Agenda Item: Construction Traffic and Access

From [REDACTED], Gt Staughton Parish Council [REDACTED]

Client
BSSL Cambsbed 1 Ltd
Project
East Park Energy
Drawing Title

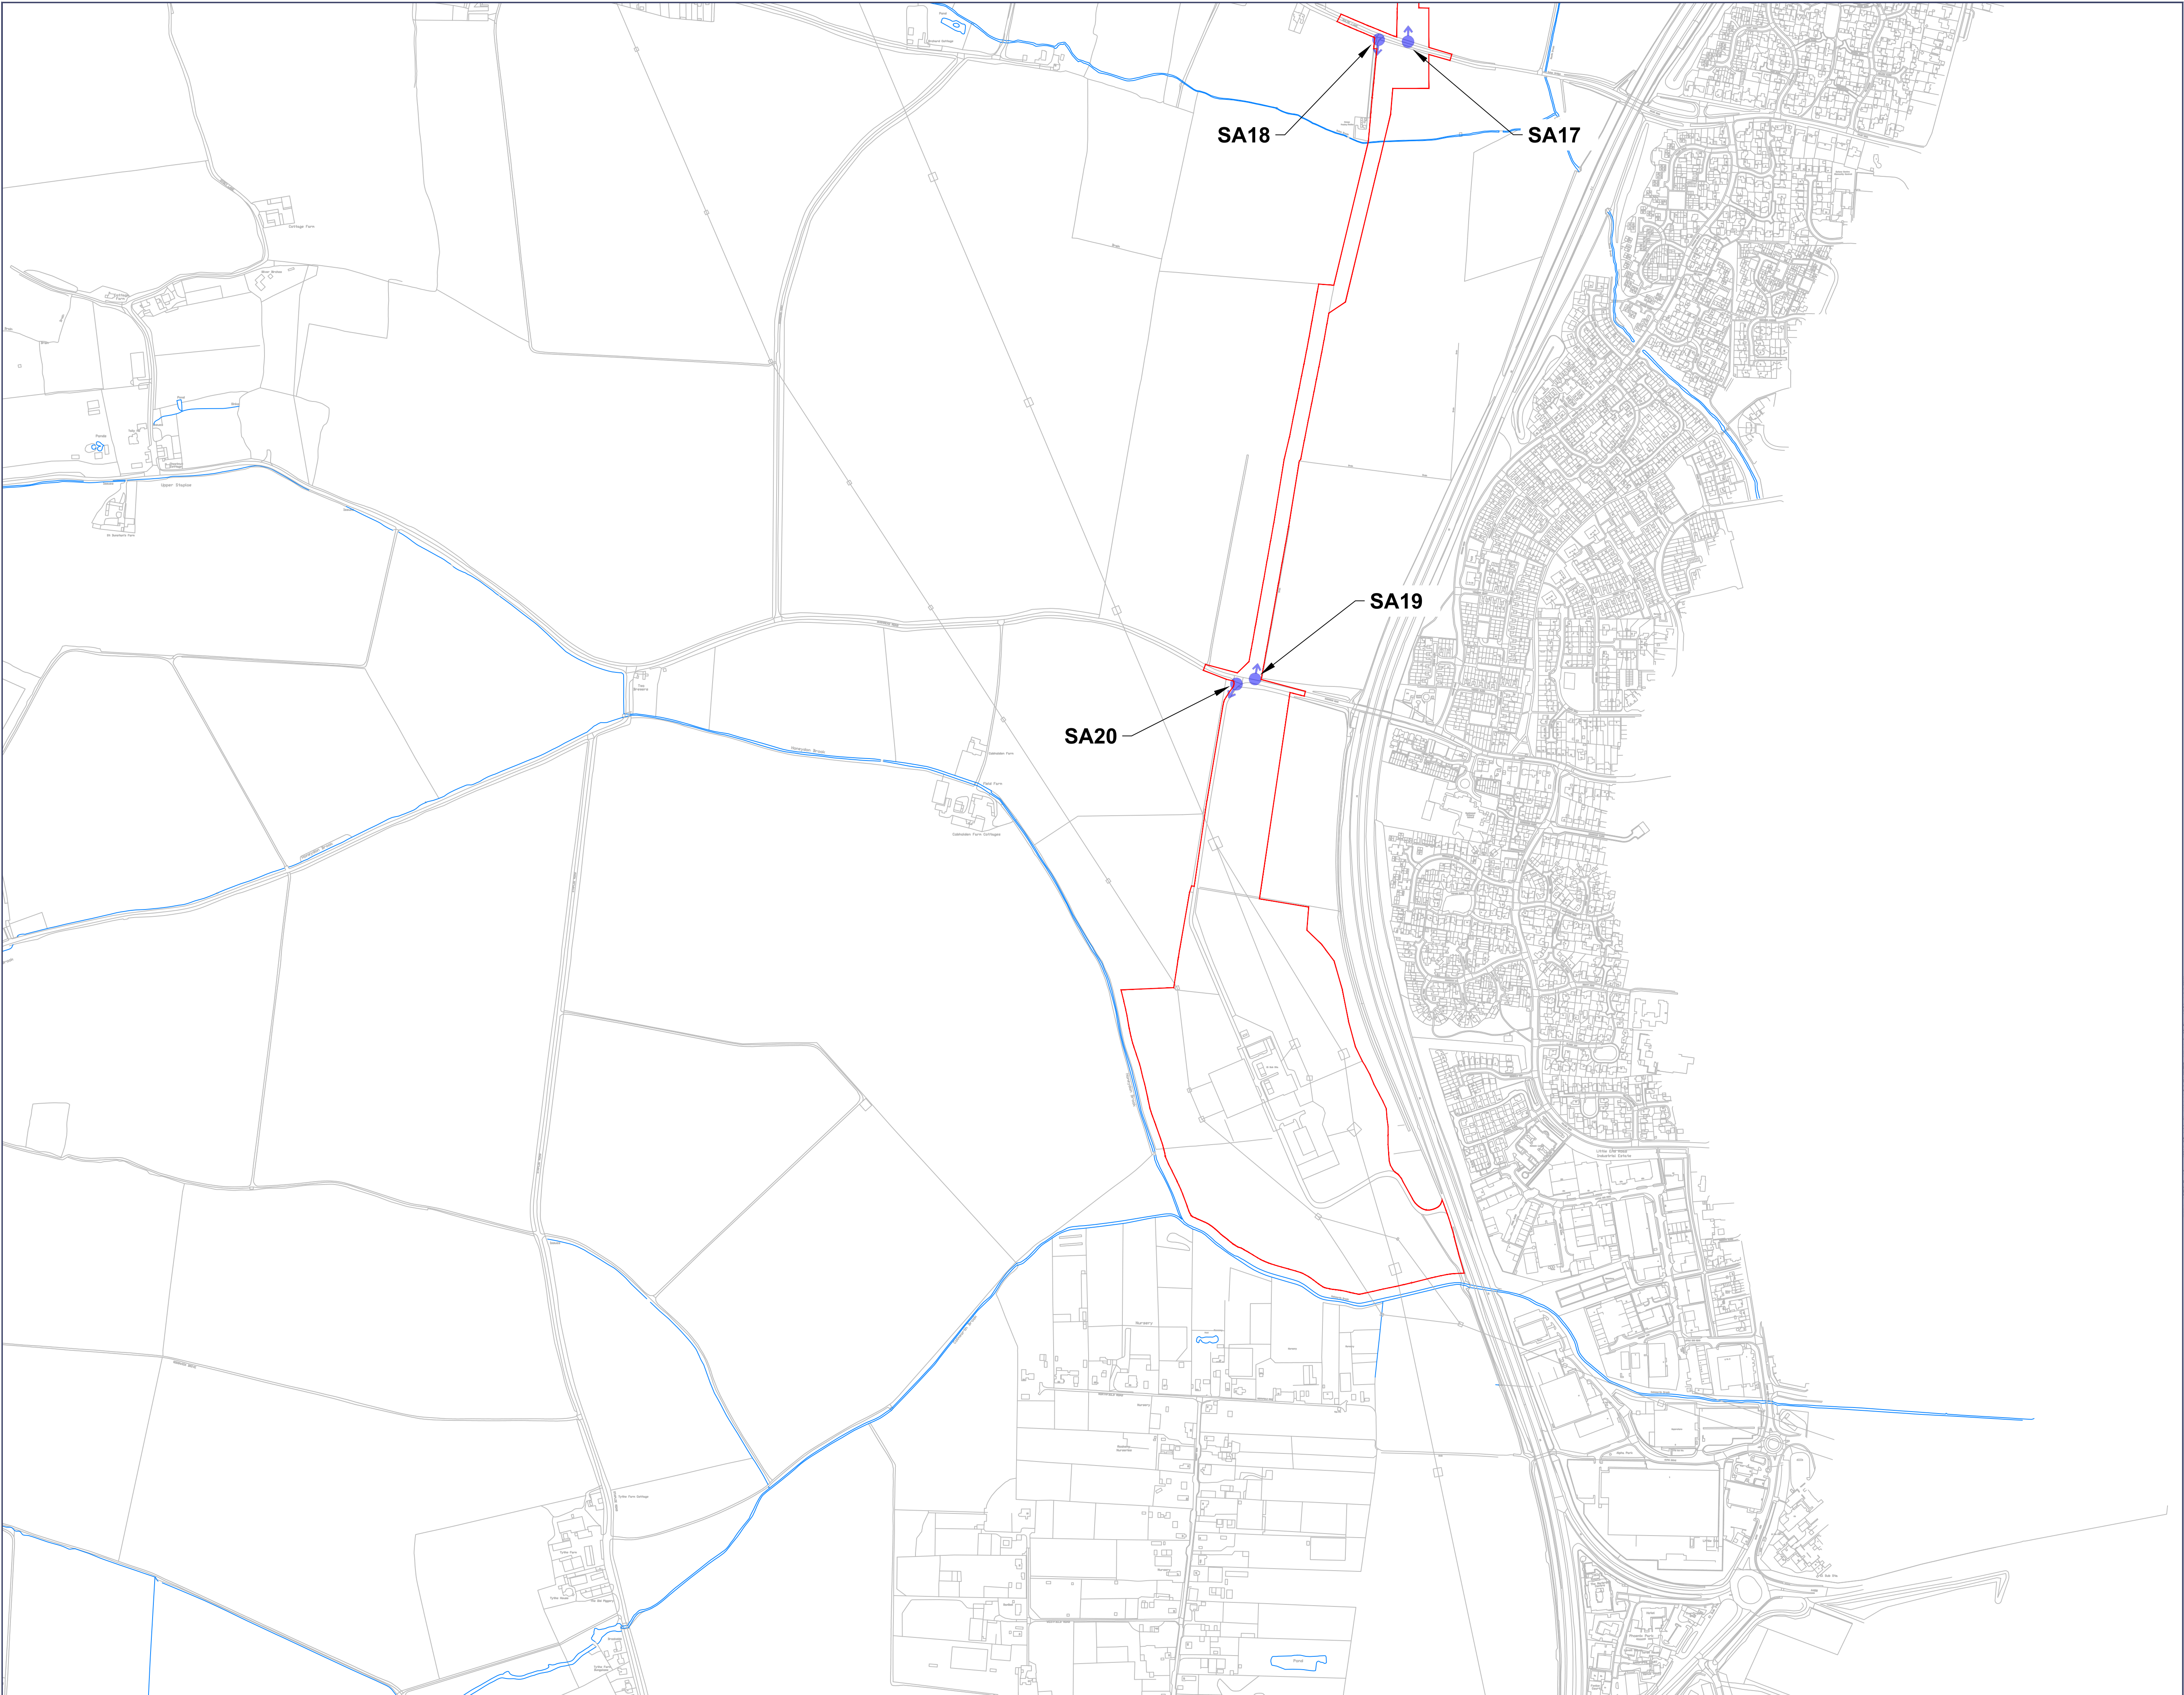
We understand that Brockwell's intention is for all the site traffic to come from the A1 along the B645 and enter the point at SA16. However, we would like to see a commitment that this will be strictly enforced otherwise we suspect that construction traffic including HGVs will be tempted to take the shortcut from SA12 back through the village in a way that would be exceedingly dangerous and disruptive:

B645 (MAIN ACCESS SA16 to site D). This stretch of road is considered locally to be extremely dangerous:

We are concerned that the project will cause obstruction on the B645 (especially around the main site D access SA16) which is the route to and from work school and shops for many parish residents. Any blockages, hold-ups or temporary traffic signals will come at a significant economic and social cost to local residents.
